Comments / Objections re Planning Application 2021/62/91239/W

410/412 Birkby Road , Birkby Huddersfield, HD2 2DN

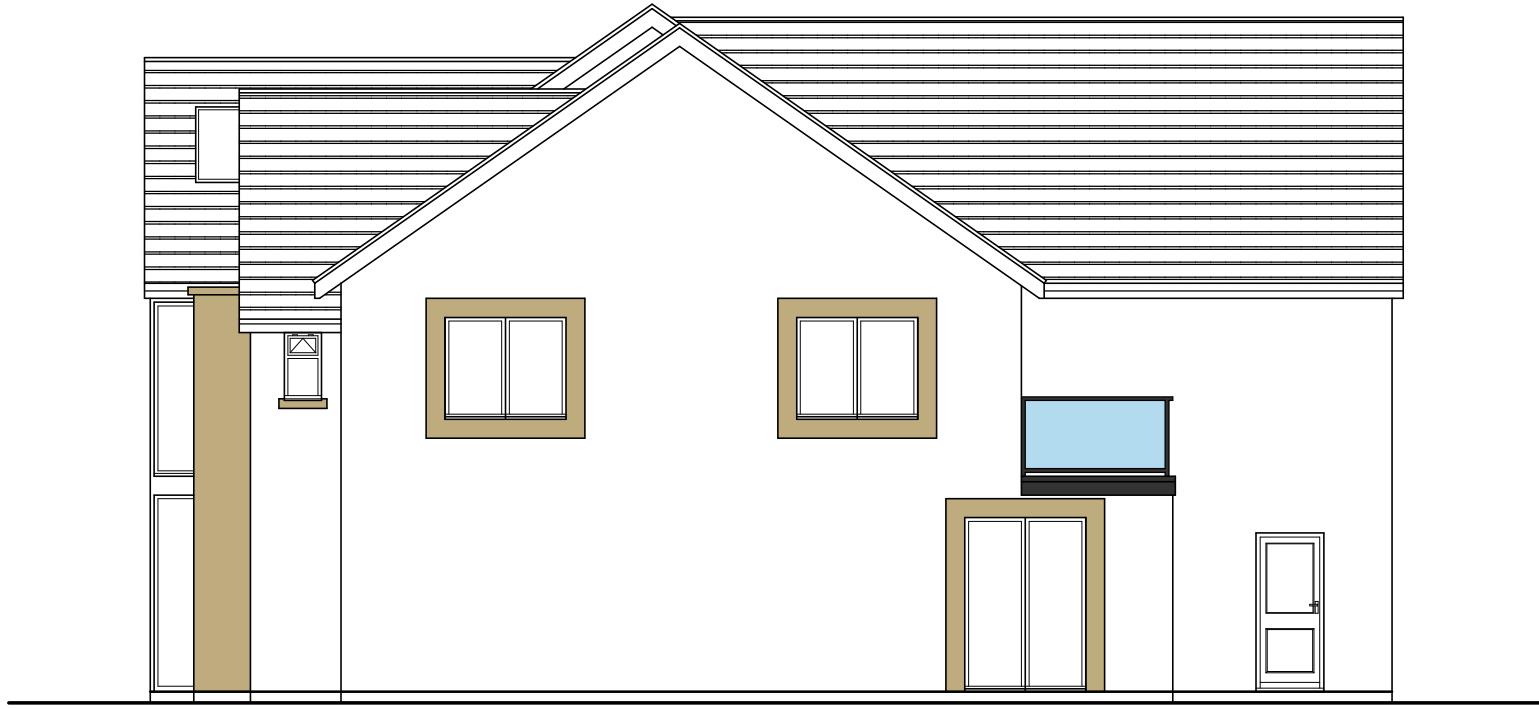
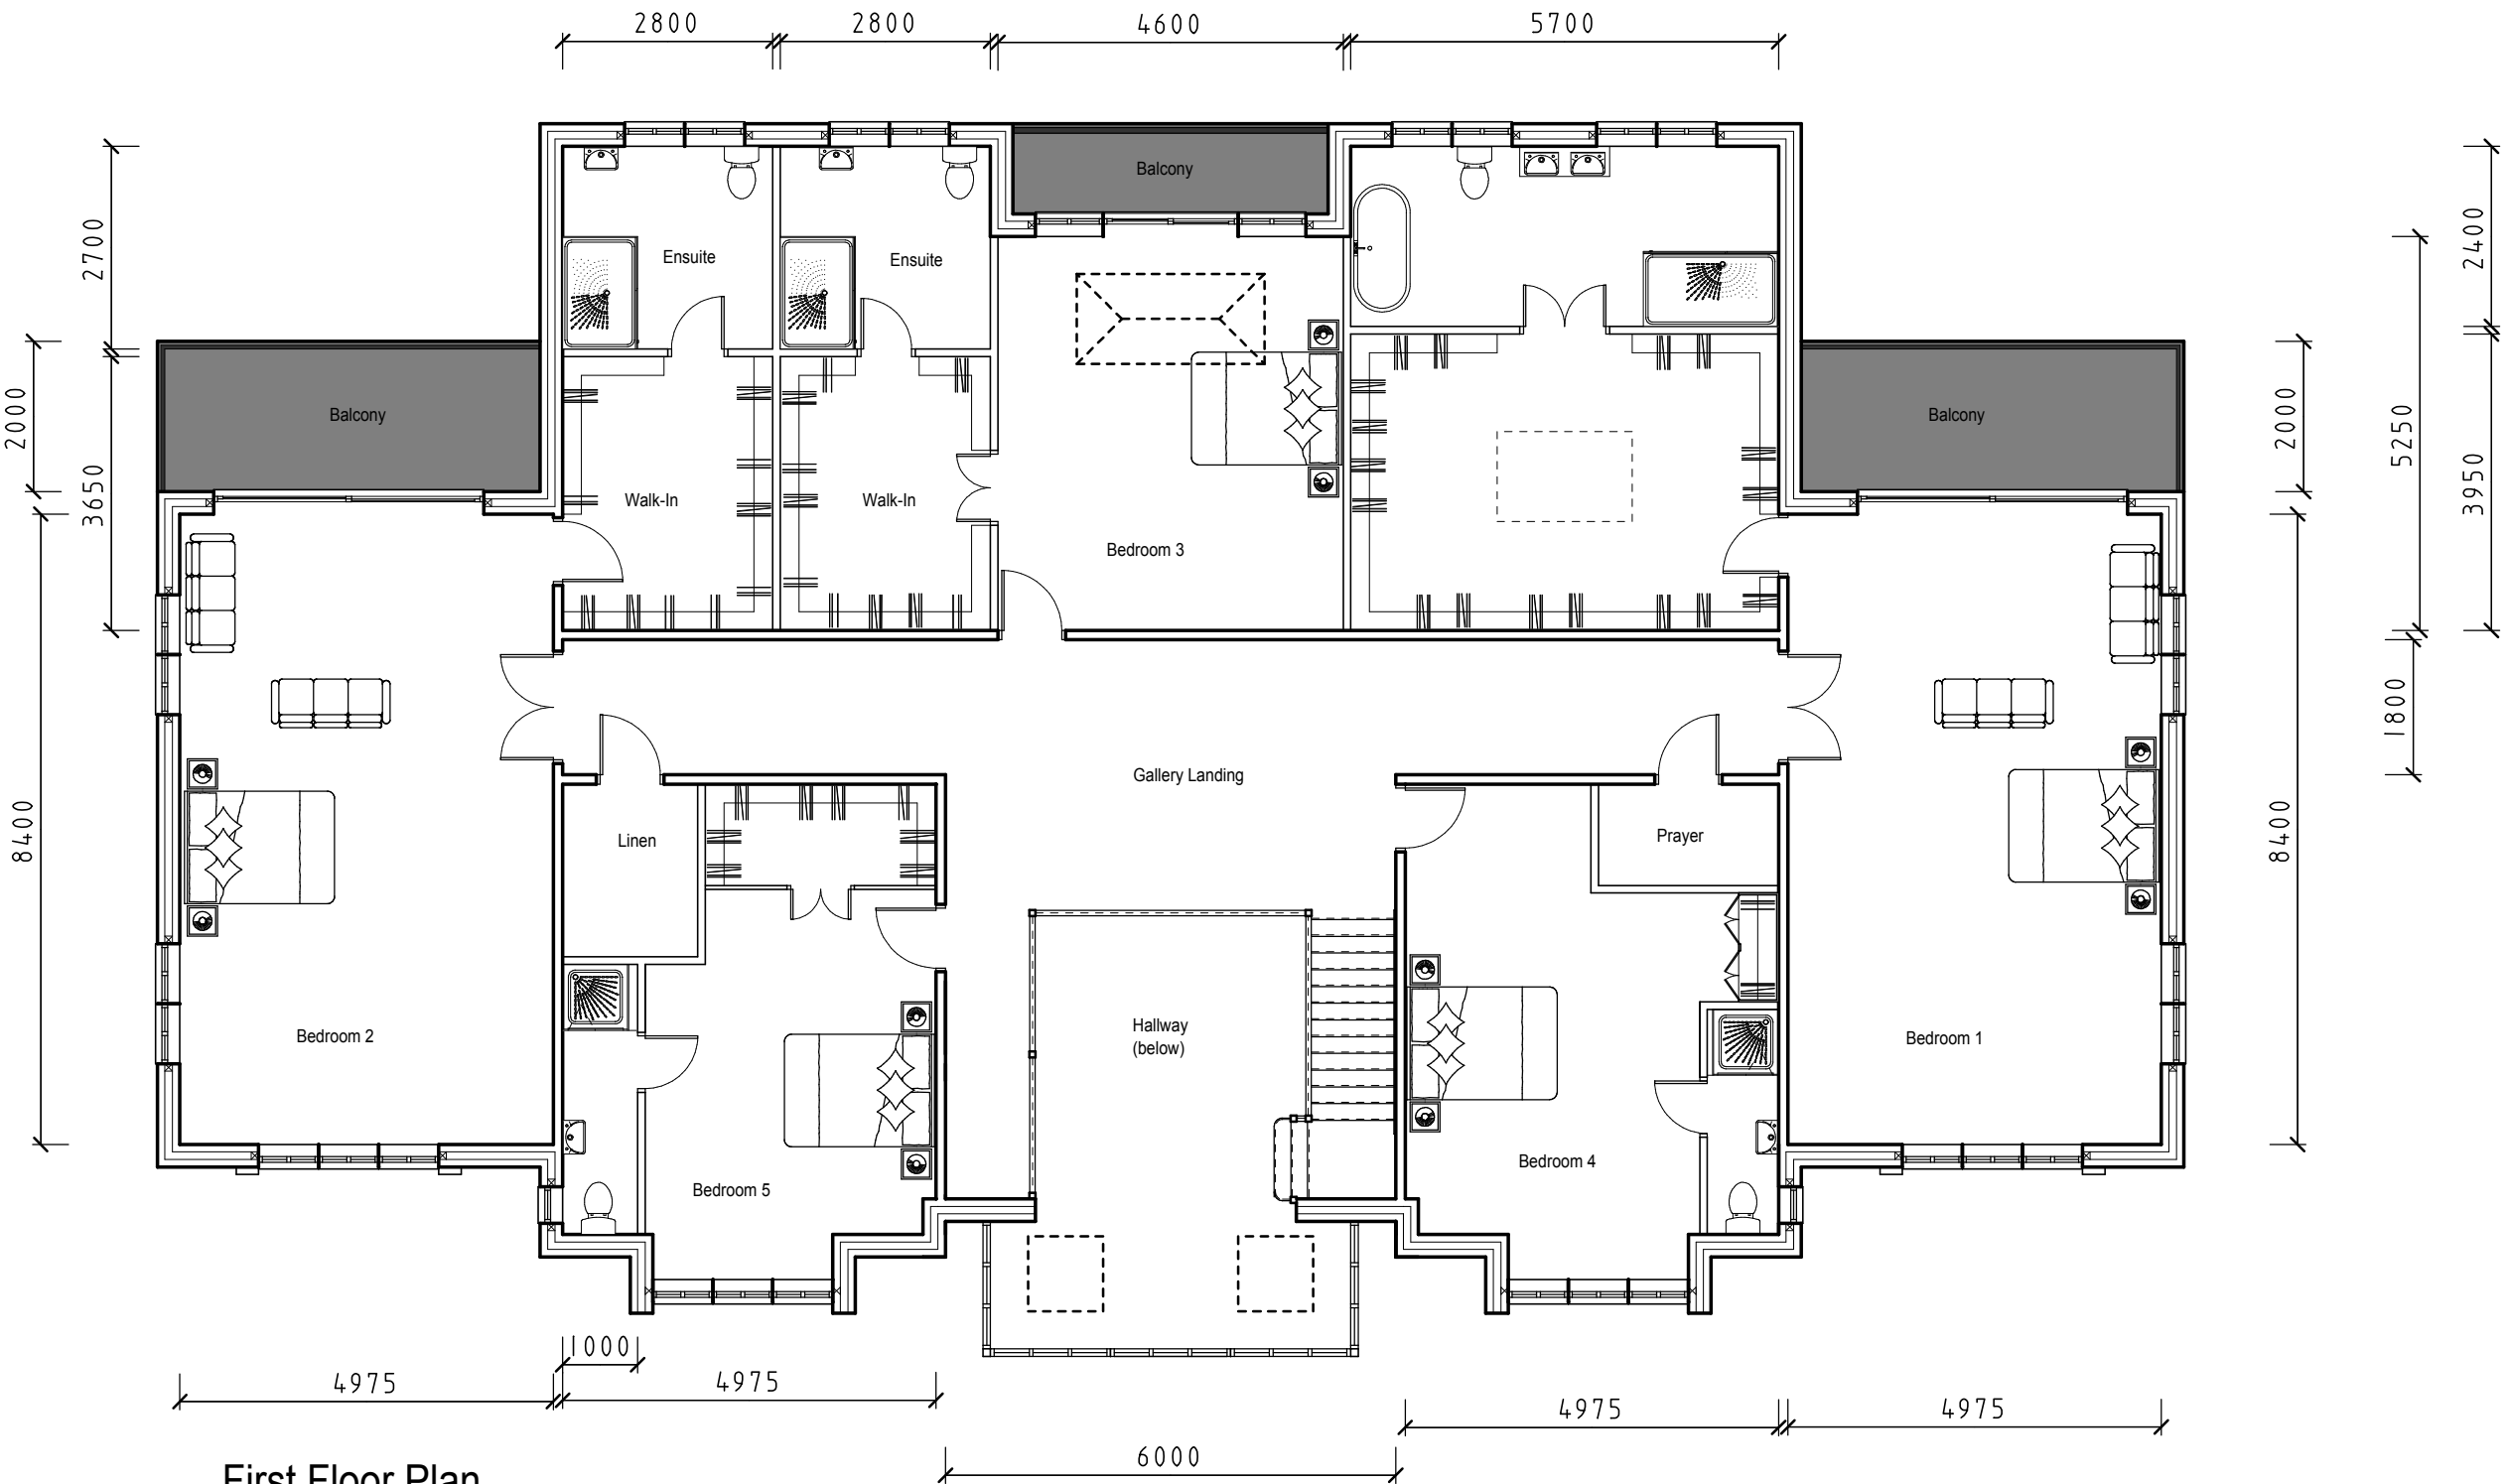
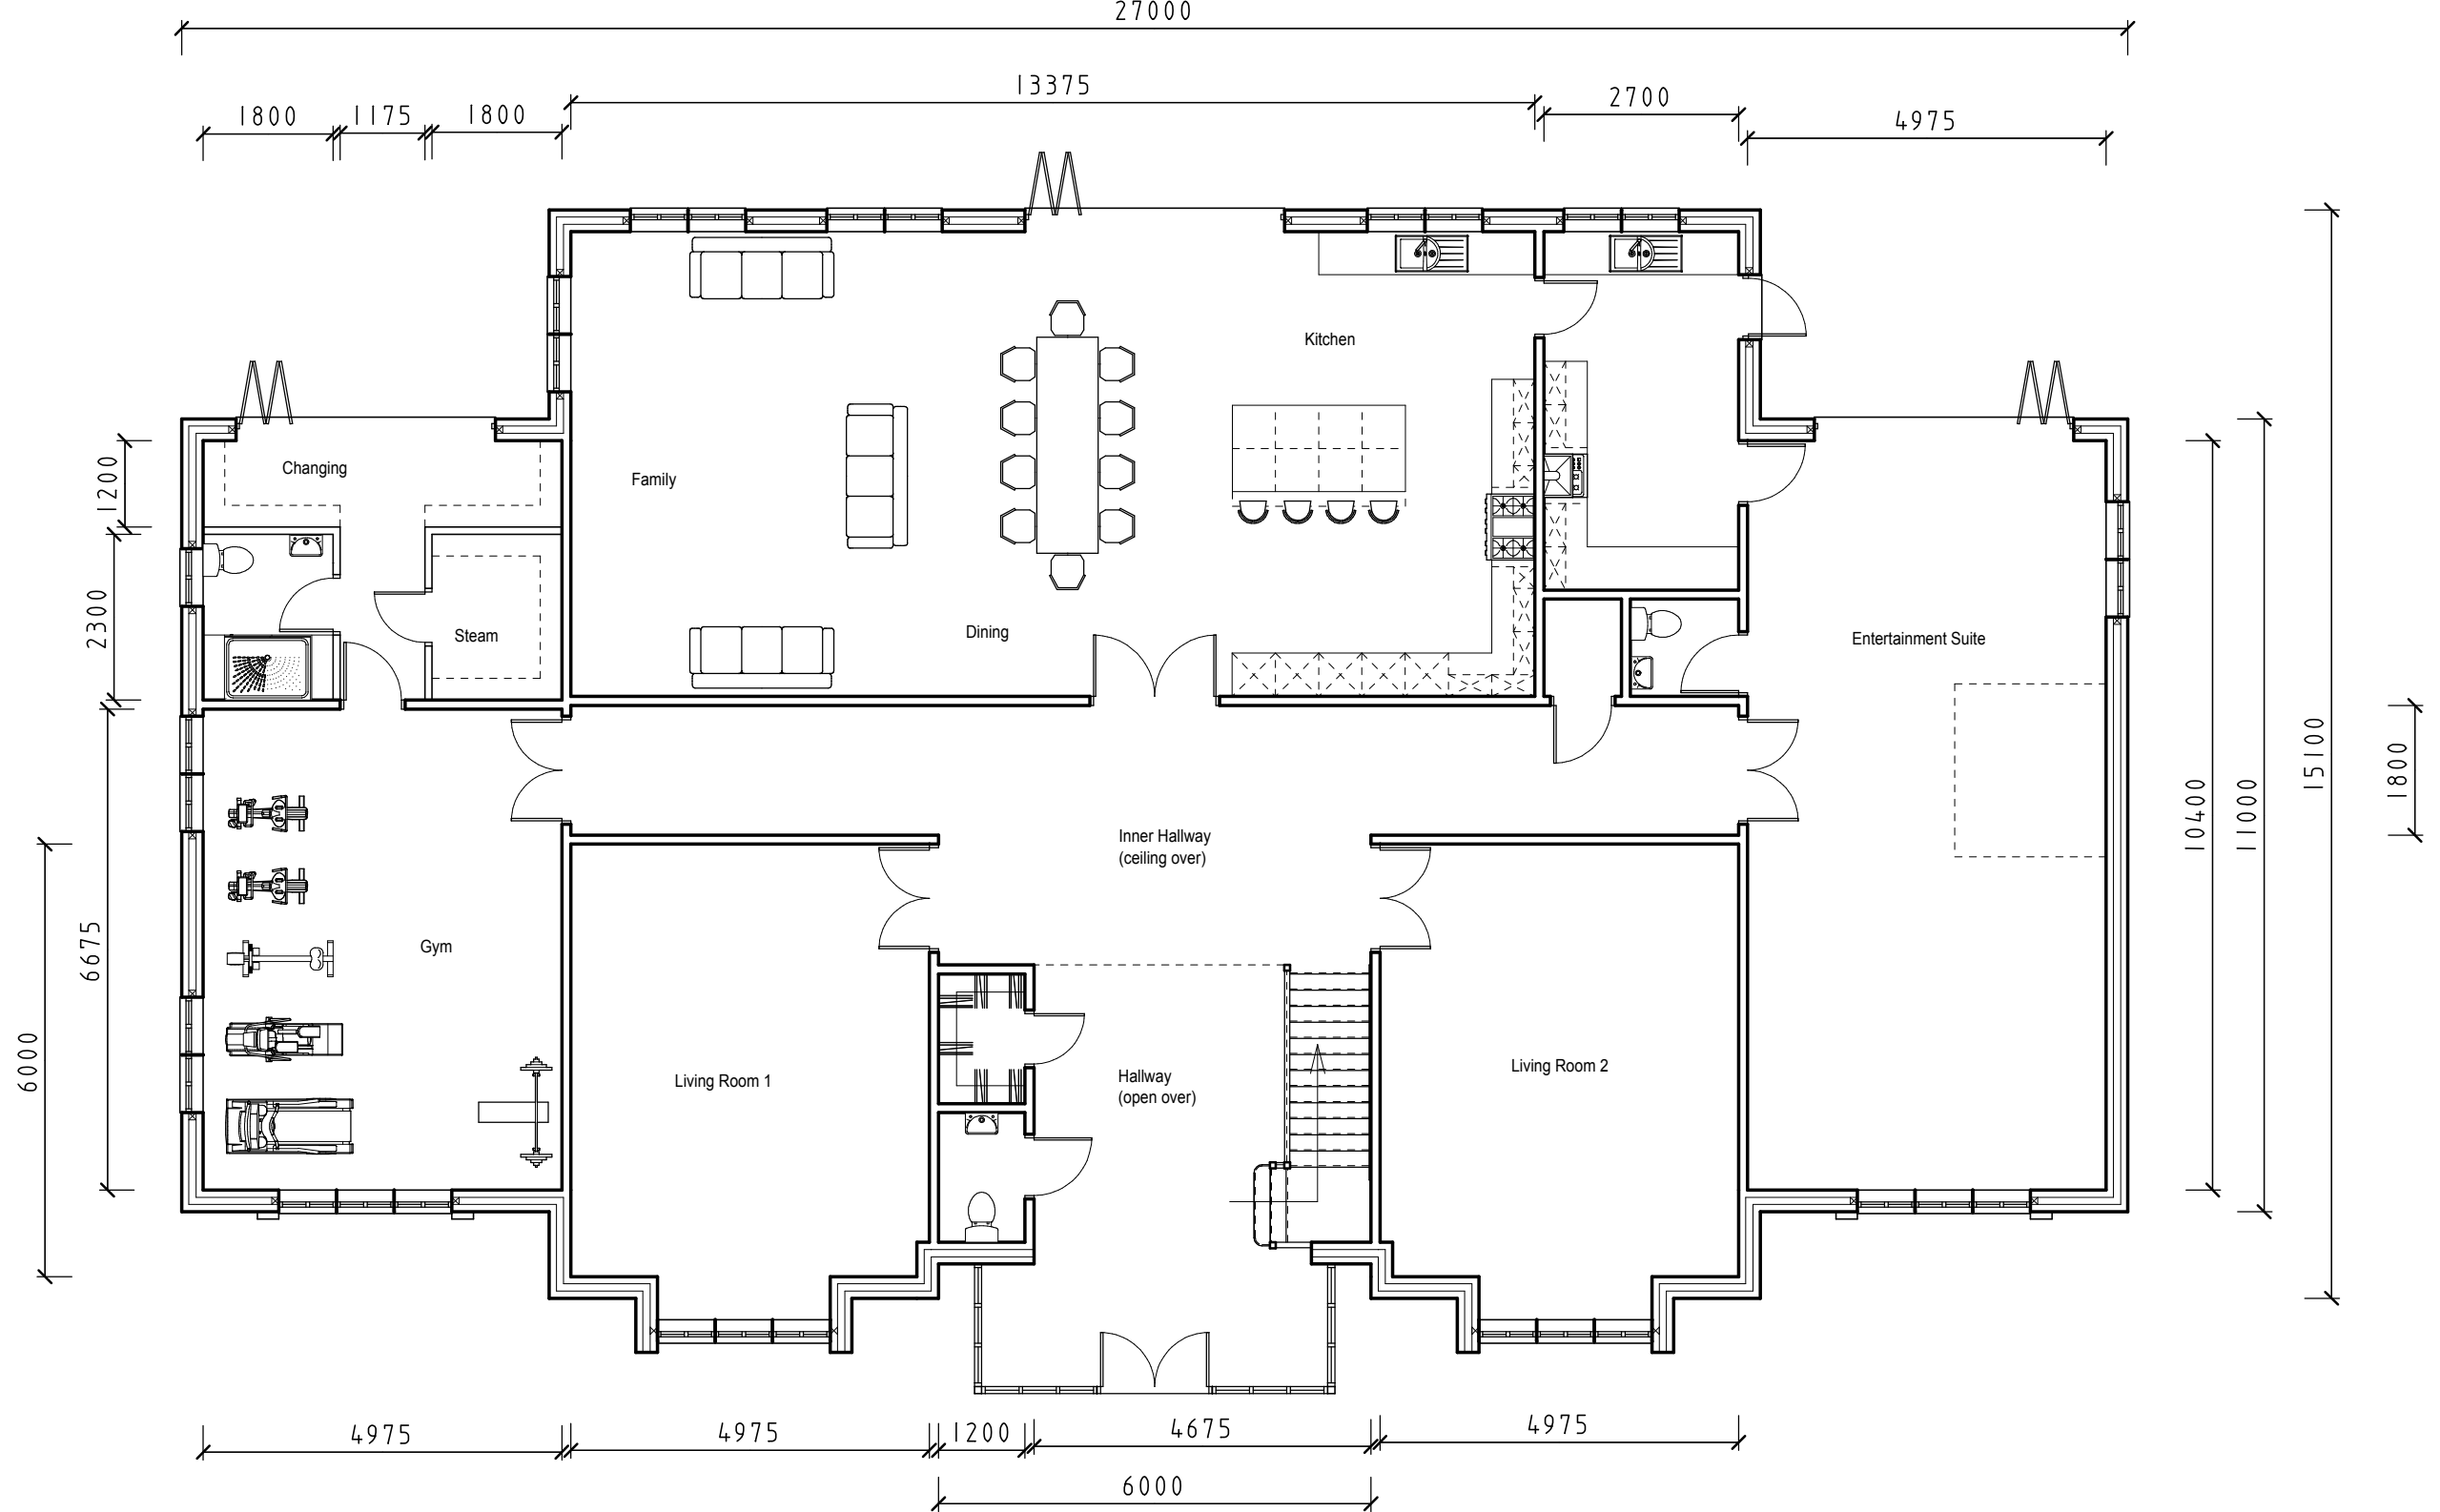
- The ‘Home Office’ and Garage for property 412 would appear to be very large. The plans appear to show five desks, bathrooms with toilets and showers, in a ‘Home Office’ is this change of use in order to run a business from this address? Why the need for parking of 15 vehicles if it is for two five bedroom houses? This appears to be a change of use to create office space.
